Case Officer: James Kirkham **Recommendation:** Approve

Applicant: Langham Holdings Ltd

Proposal: Conversion of upper floors to apartments. New access in front facade

GSG_001

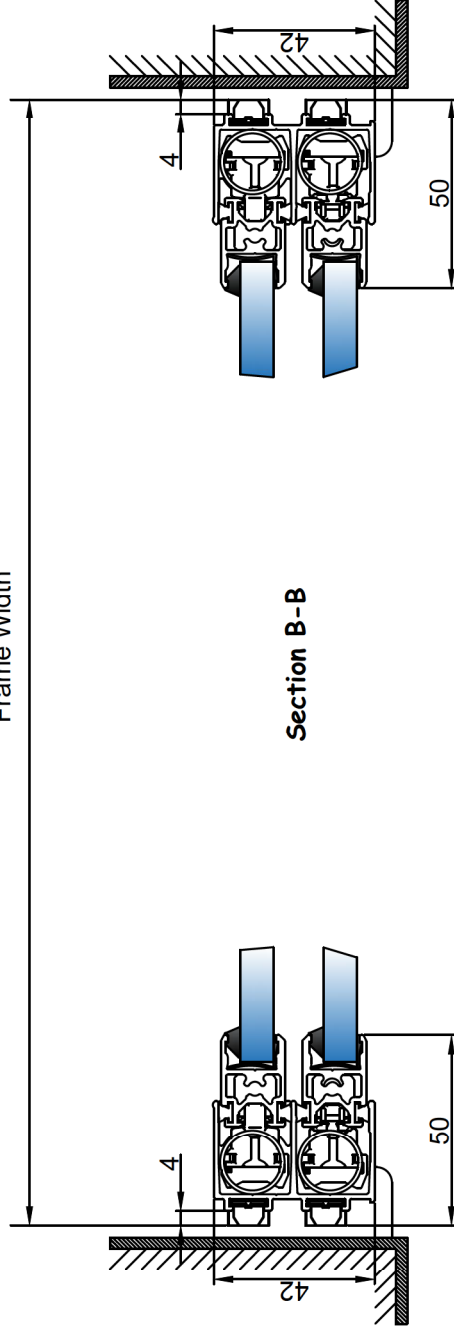
- 8.7. The external changes to the building largely relate to the replacement and additional of new windows. These include a mix of sliding sash windows and casement windows. Where windows are replaced, modern windows would be replaced with more traditional style windows. The arrangement and style of windows is considered to be acceptable subject to condition. Whilst a typical section of a timber sliding sash window has been provided with the application this does not include details of the recess of the window from the brick face or the cill or header details.

- Where new windows or doors are proposed full details of the doors and windows, at an appropriate scale including a cross section, cill, headers and recess detail and colour/finish, shall be submitted to and approved in writing by the Local Planning Authority.

Drawing:
PROPOSED GROUND AND FIRST FLOOR PLANS

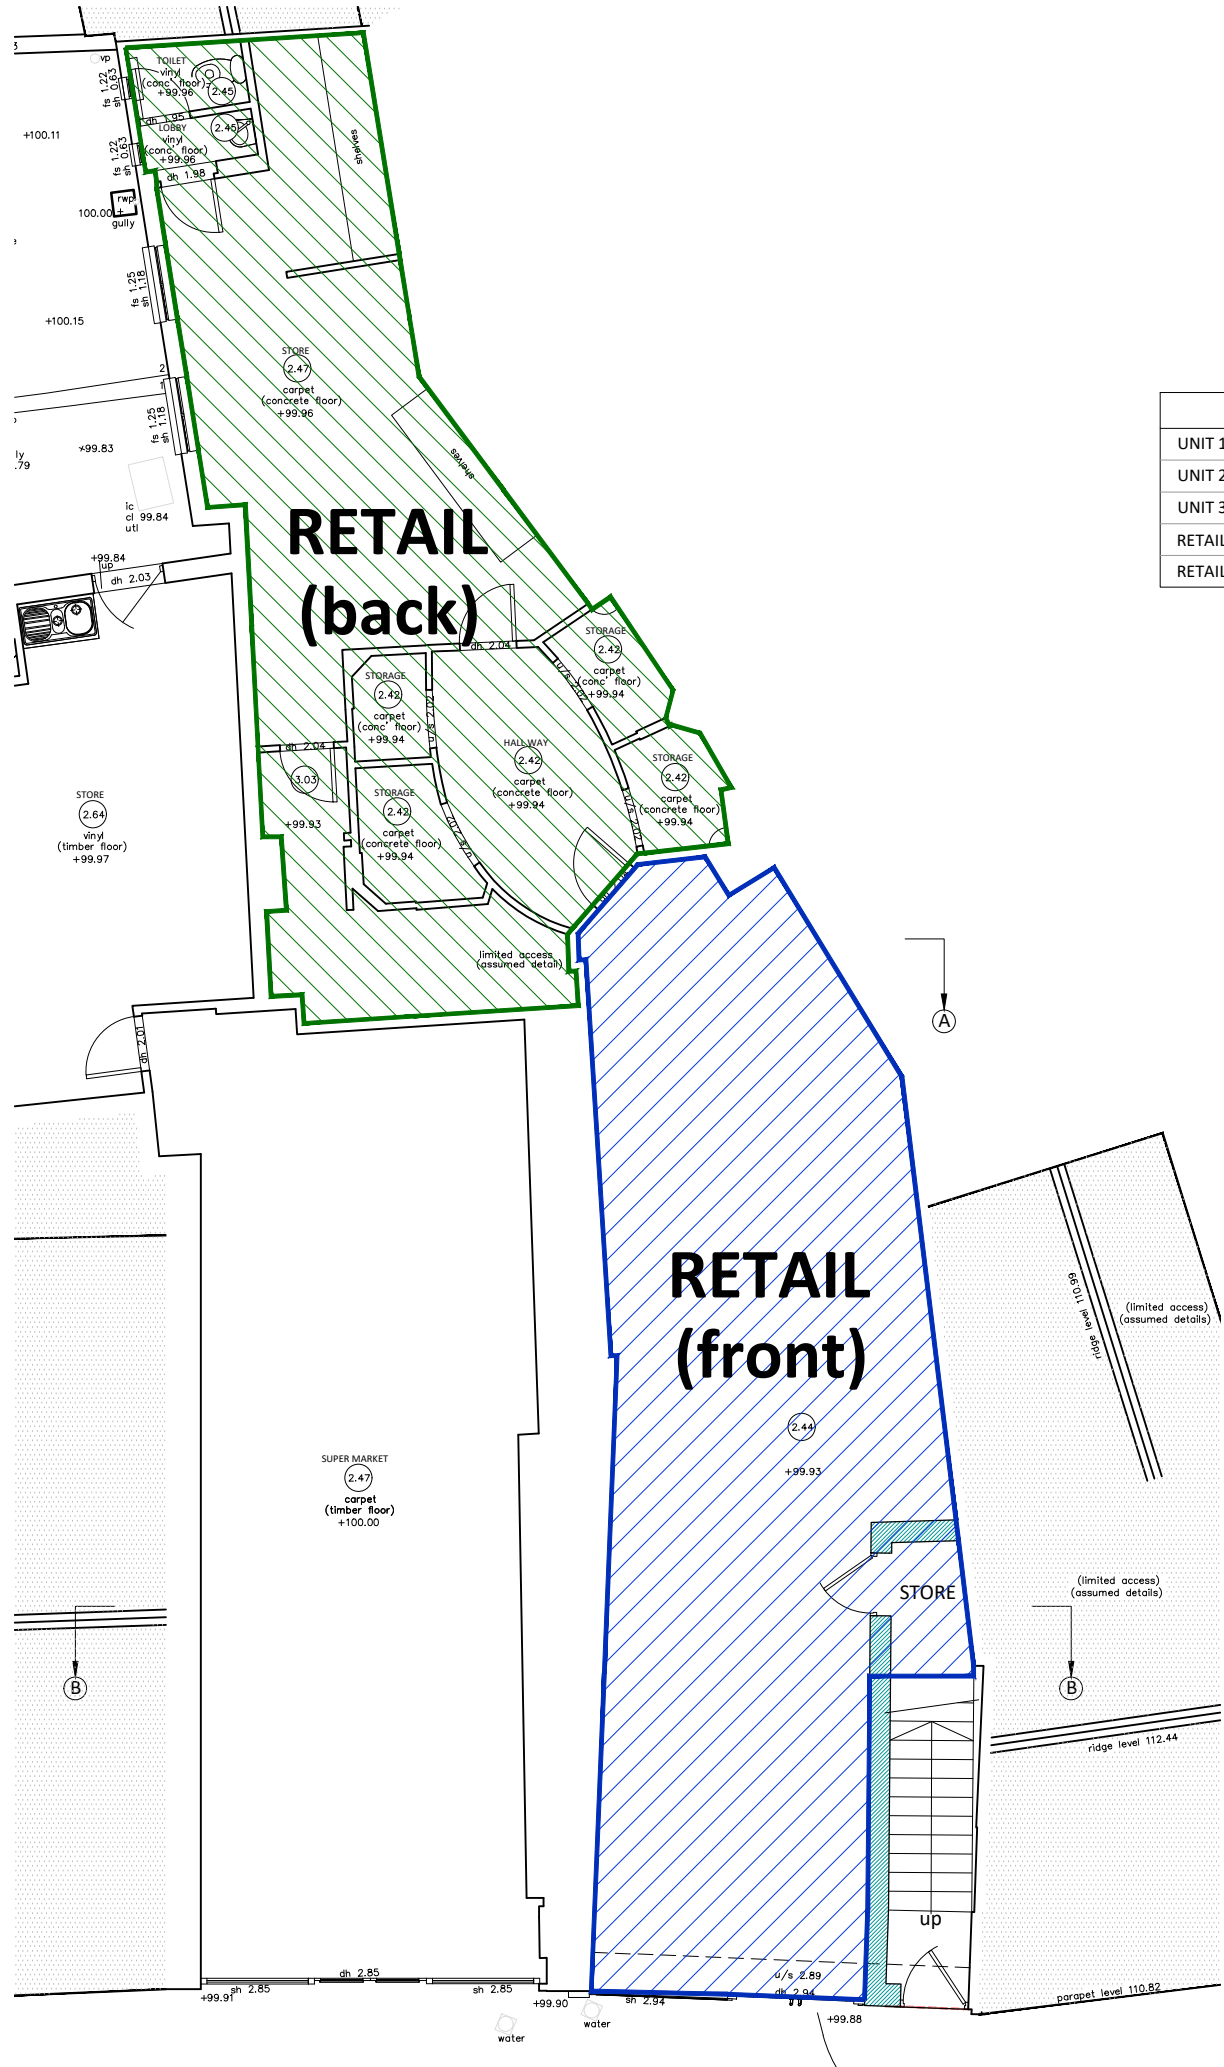
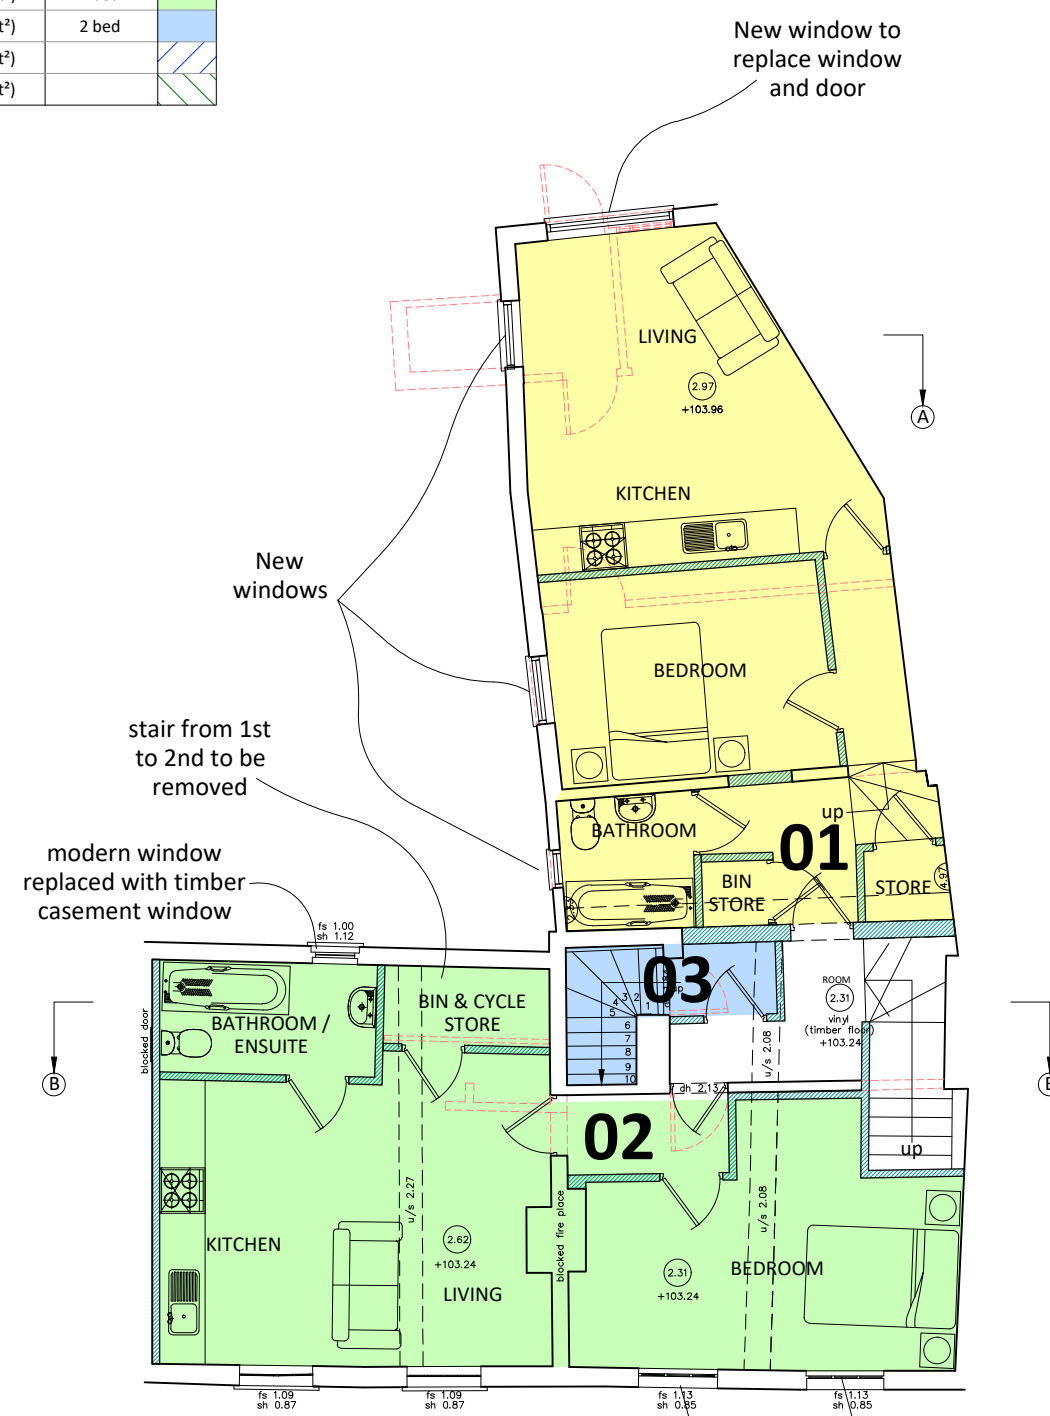
- 8.8. The alteration to the shop front to create a new access for the residential properties is not ideal and disrupts the unity of the shop frontage. It is noted that other such interventions have happened in the street with varying degrees of success. Amended shop front details have been sought and these are considered to be an improvement on the initial proposals. However, full details of the shop front would need to be provided.

- 8.9. Internally the works have been considered by the Conservation Officer who now raises no objection to the works subject to conditions. During the course of the application the plans have been amended to reduce the impact on historic fabric such as chimney breasts and other details. The proposal does not result in the loss of the stair between first and second floor however this is considered to be justified to provide a new use for the building and retained other features such as the cranked chimney breasts.

existing shop front, full details of the proposed new shop front and access to the flats including, sections drawings, materials and finish shall be submitted and approved in writing by the Local Planning Authority. The new shop front shall thereafter be completed in accordance with the approved details prior to the first occupation of any dwelling hereby permitted and shall be retained as such thereafter.

WG1103-009 B

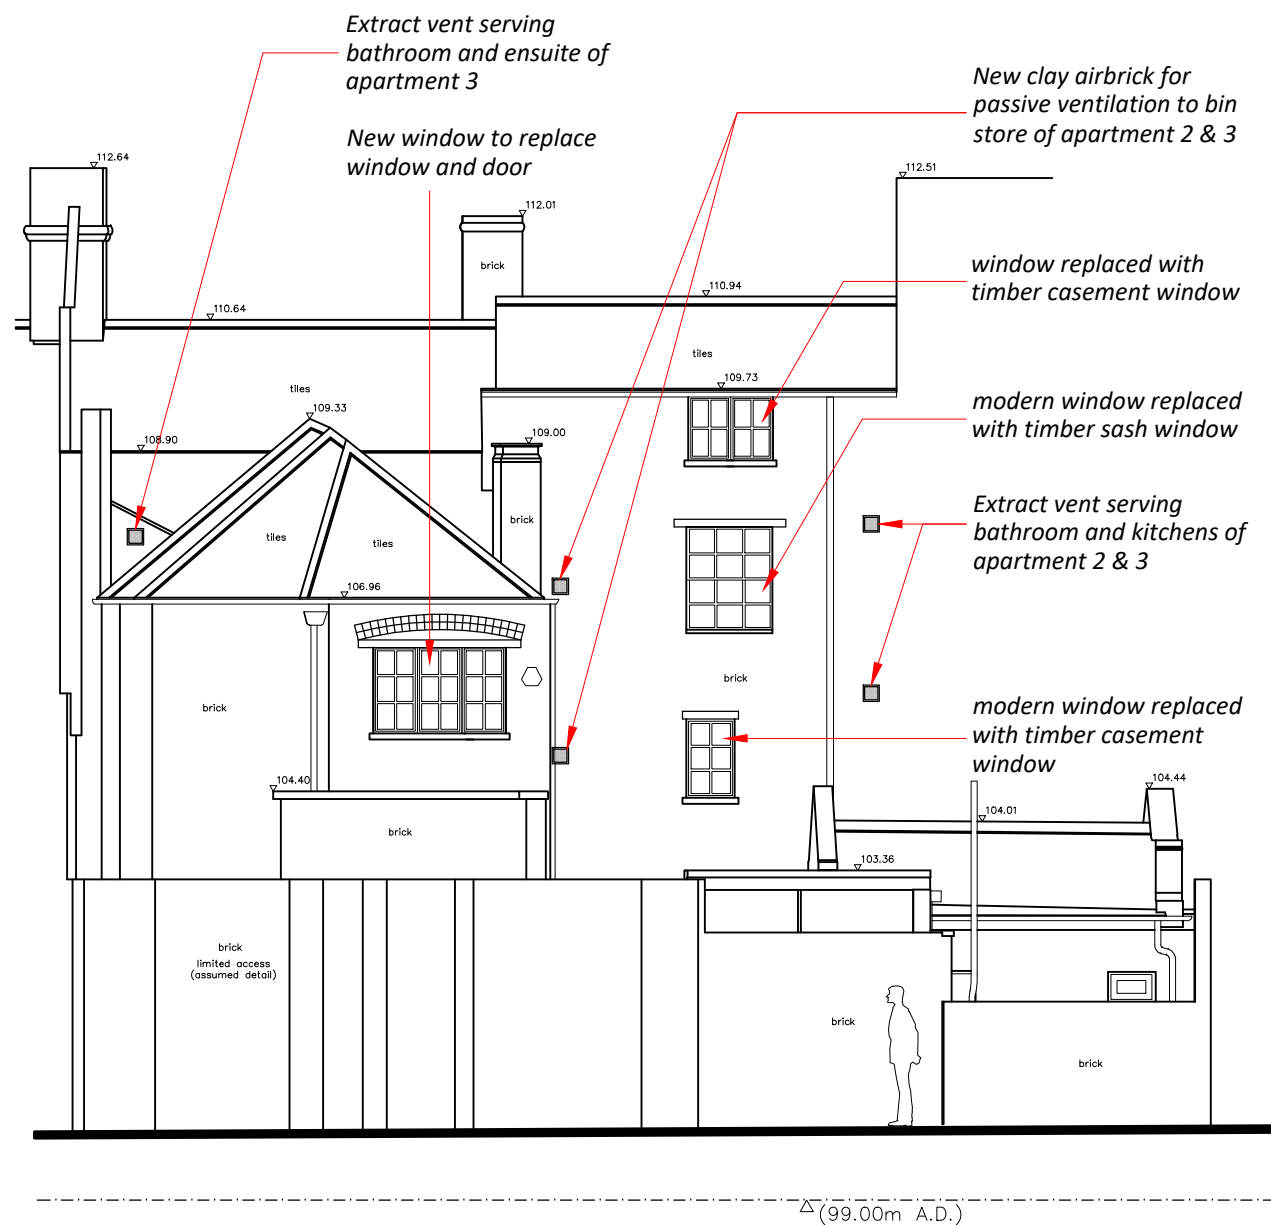
Furthermore, there are no details of the timber casement windows proposed. Therefore, conditions would be required in this respect.
